**Application No:** H02-0628-25      **Applicant:** Mr S Jaffer

**Proposal:** Details of construction management, scheme of landscaping and tree planting, proposed boundary treatments, piping and enclosure of the existing open ditch forming the boundary to Hereward Way, external materials, hard surfaced areas, external doors, door frames, window frames, roof lights, gas and electricity external boxes, gas flues and soil vent pipes, and water consumption (Conditions 3, 5, 6, 7, 8, 9, 10, 11, 12, and 16 of H02-0714-22)

**Location:** Hereward Way Crowland

Elevations

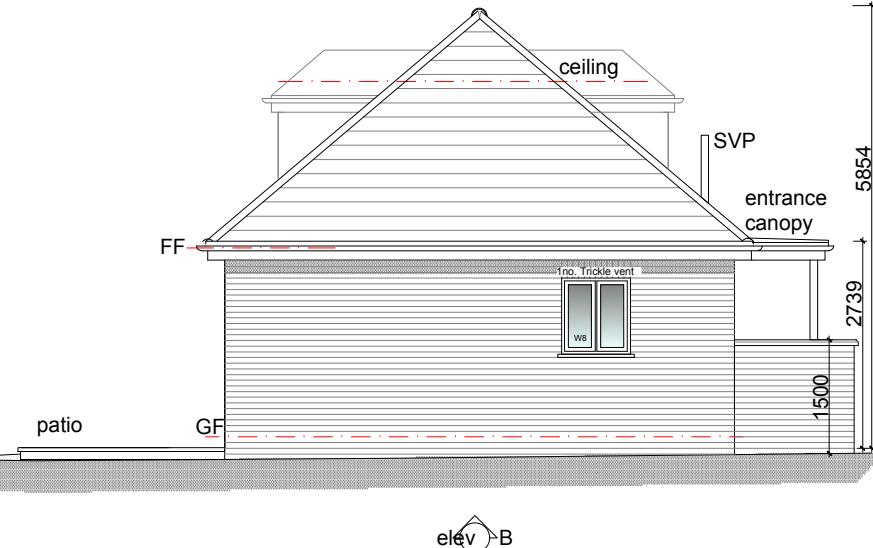
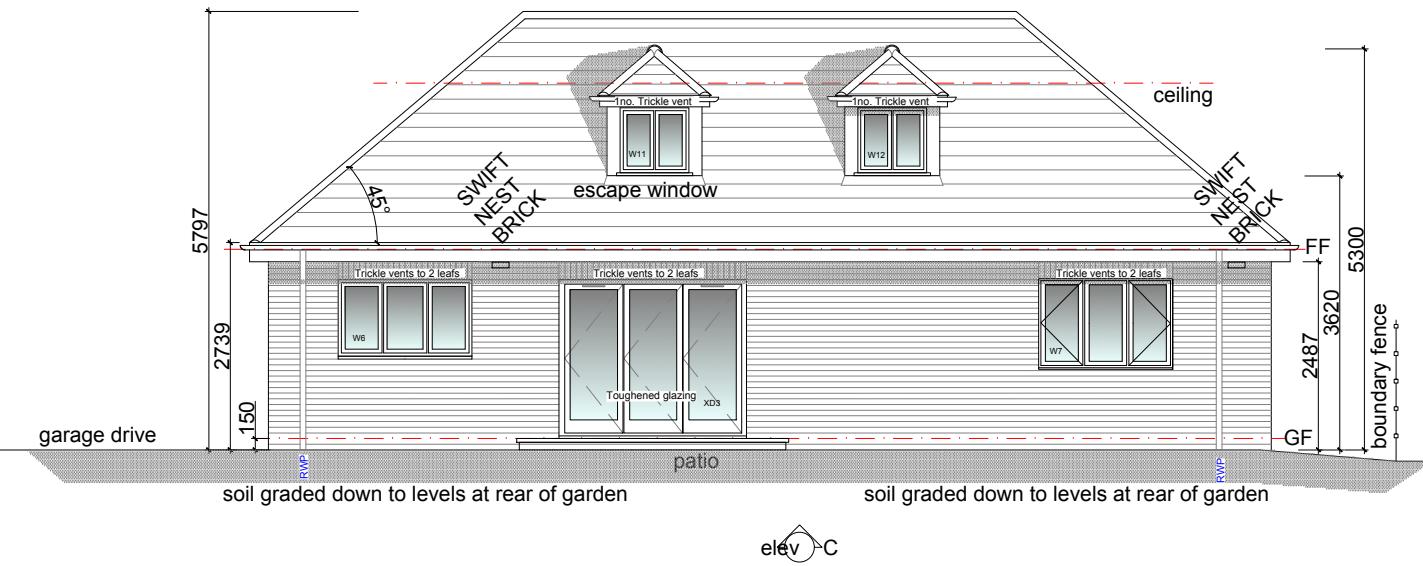
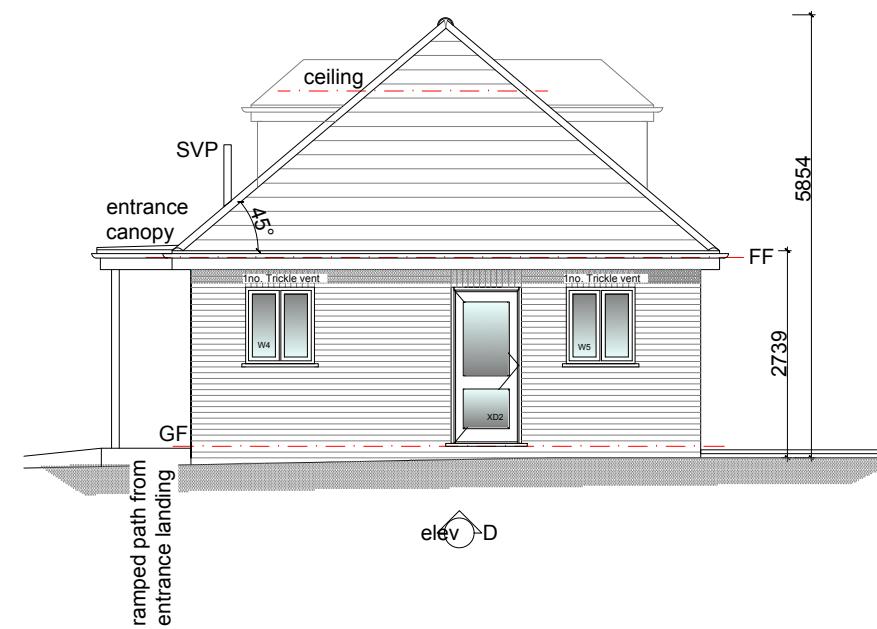
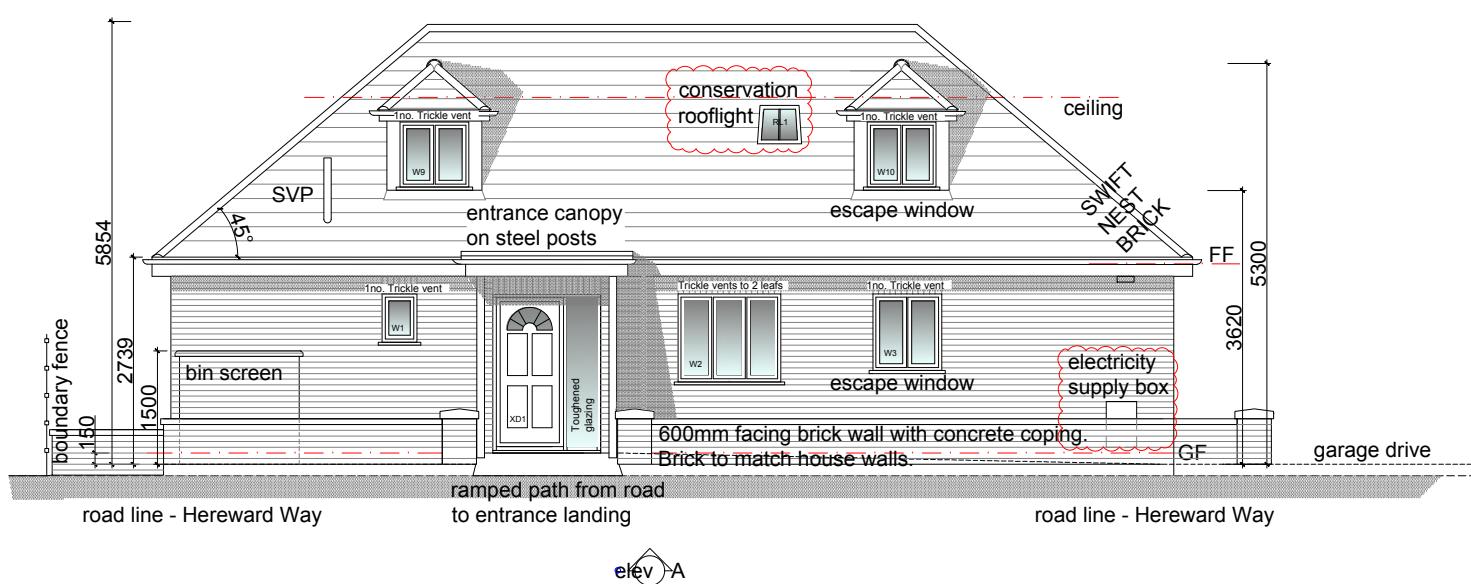
The following materials are proposed:

- Walls - Forterra Village Golden Thatch Facing Brick
- Roof - Sandtoft Double Pantiles - slate grey.
- Windows - uPVC double glazed - beige.
- Fascias & Rainwater Goods - black.

These materials are considered appropriate given the existing material palette in the wider area.

Condition 9: External Door Details

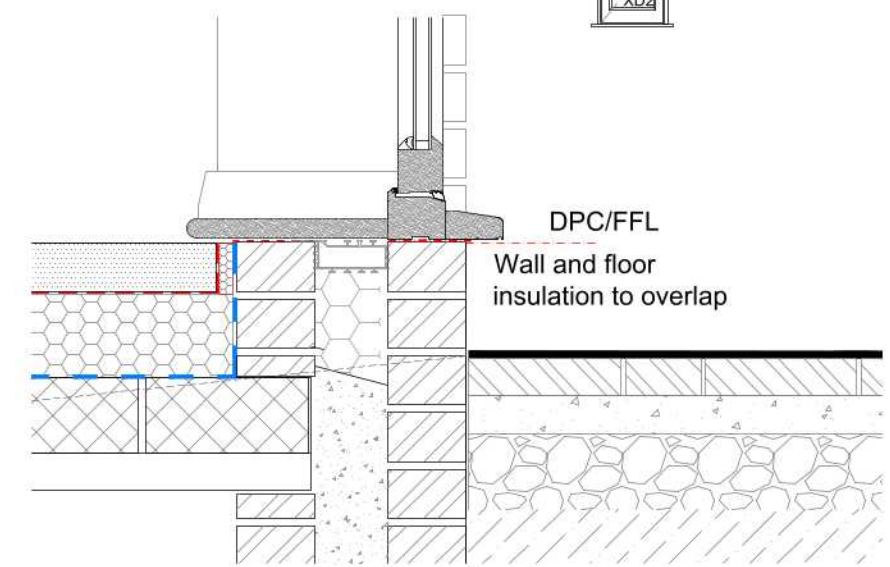
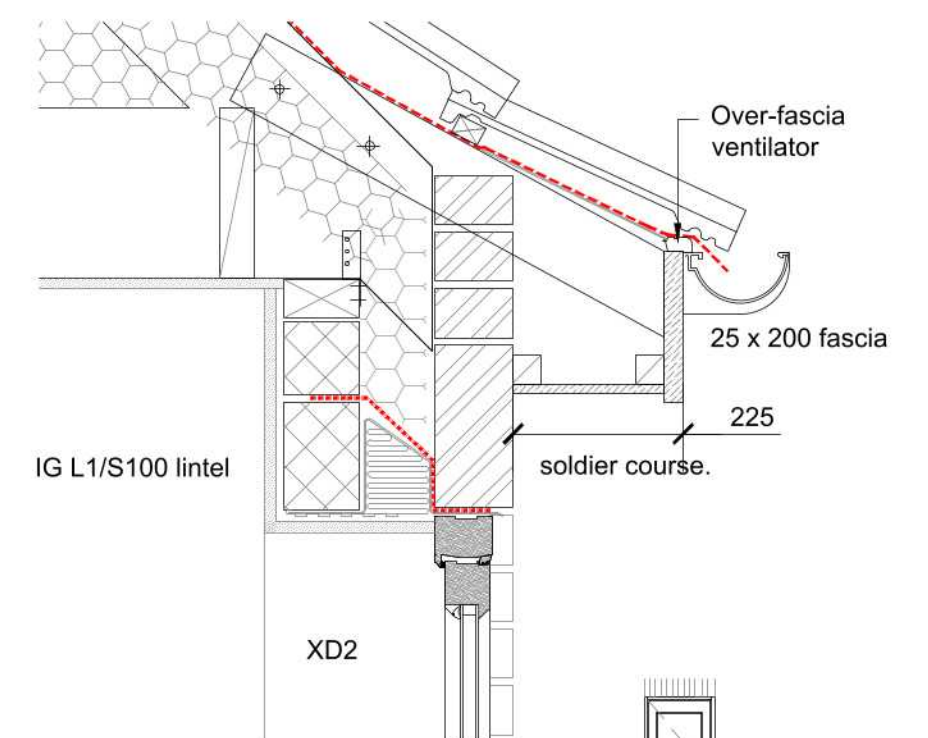
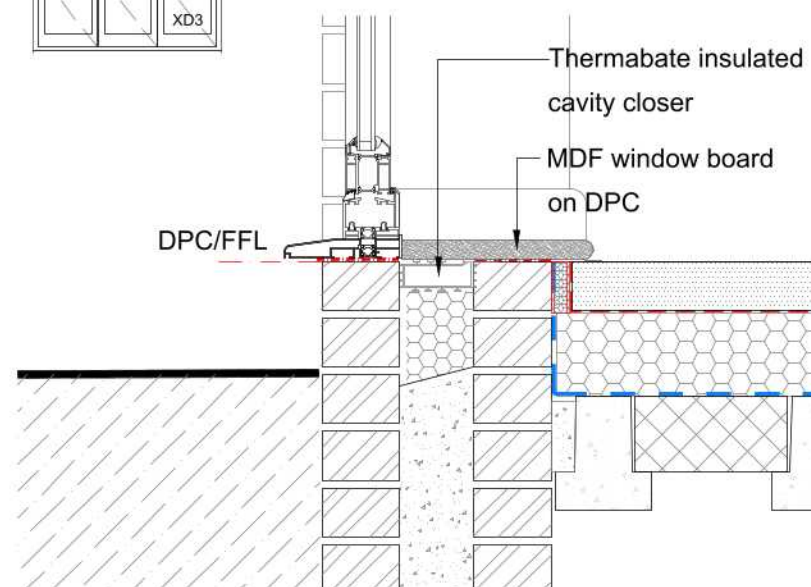
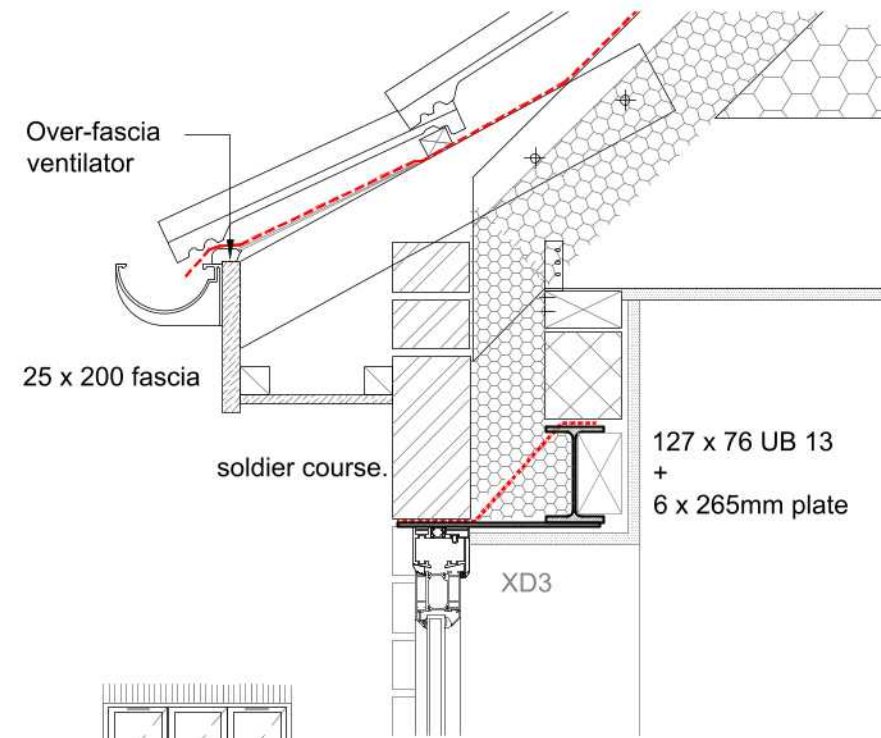
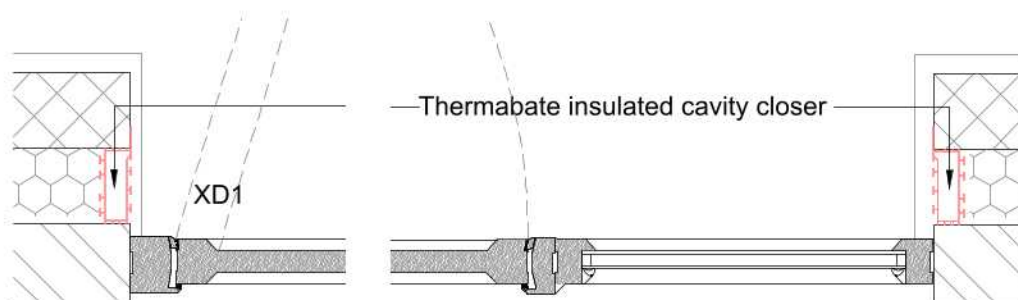
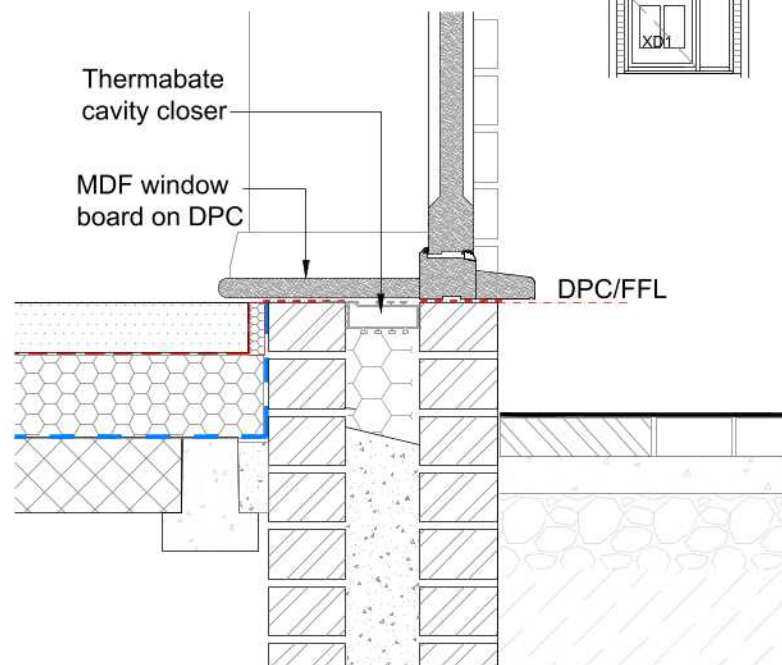
The relevant details have been provided and are acceptable. The proposed selected would have no significant detrimental impact upon the character of the area or the Conservation Area, and would be consistent with the design philosophy of the development.

Condition 10: Windows Details

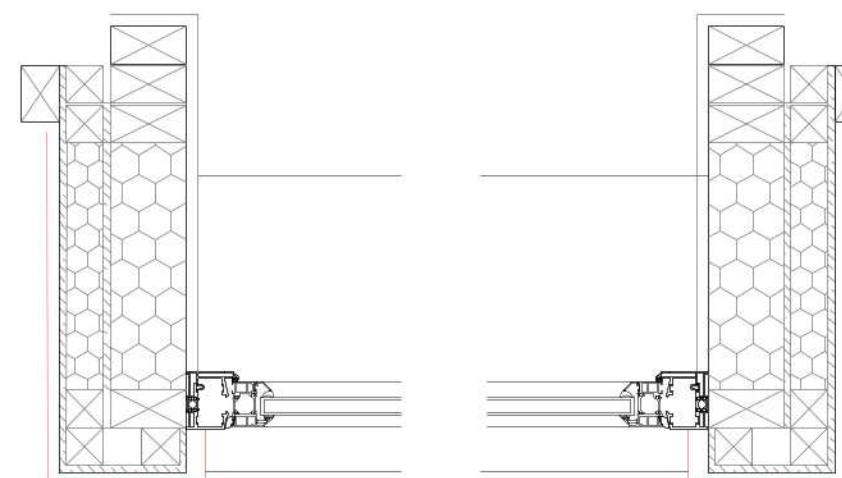
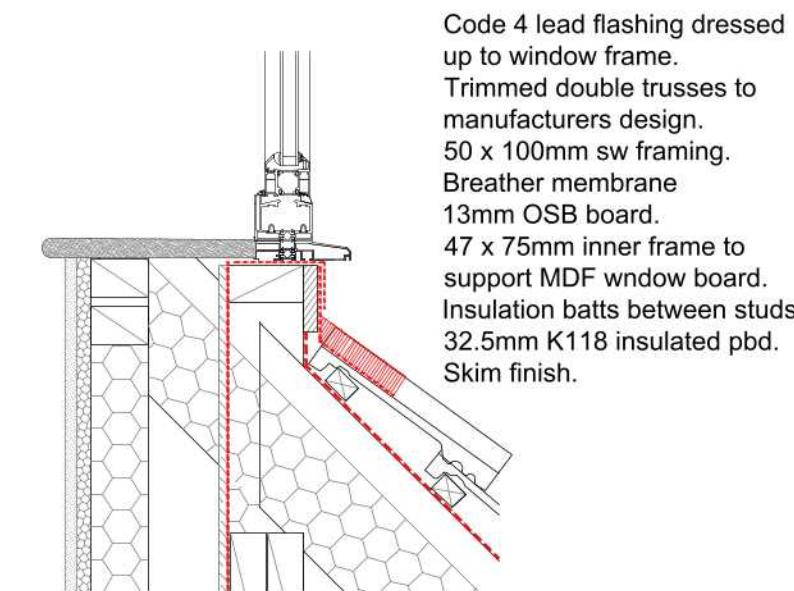
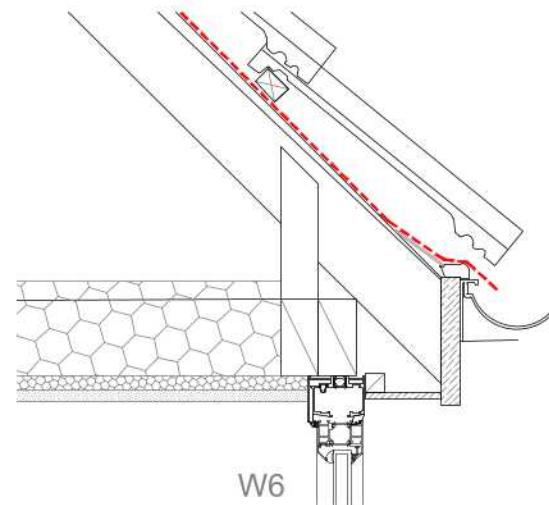
The relevant details have been provided and appear acceptable. The proposed selected would have no significant detrimental impact upon the character of the area or the Conservation Area, and would be consistent with the design philosophy of the development.
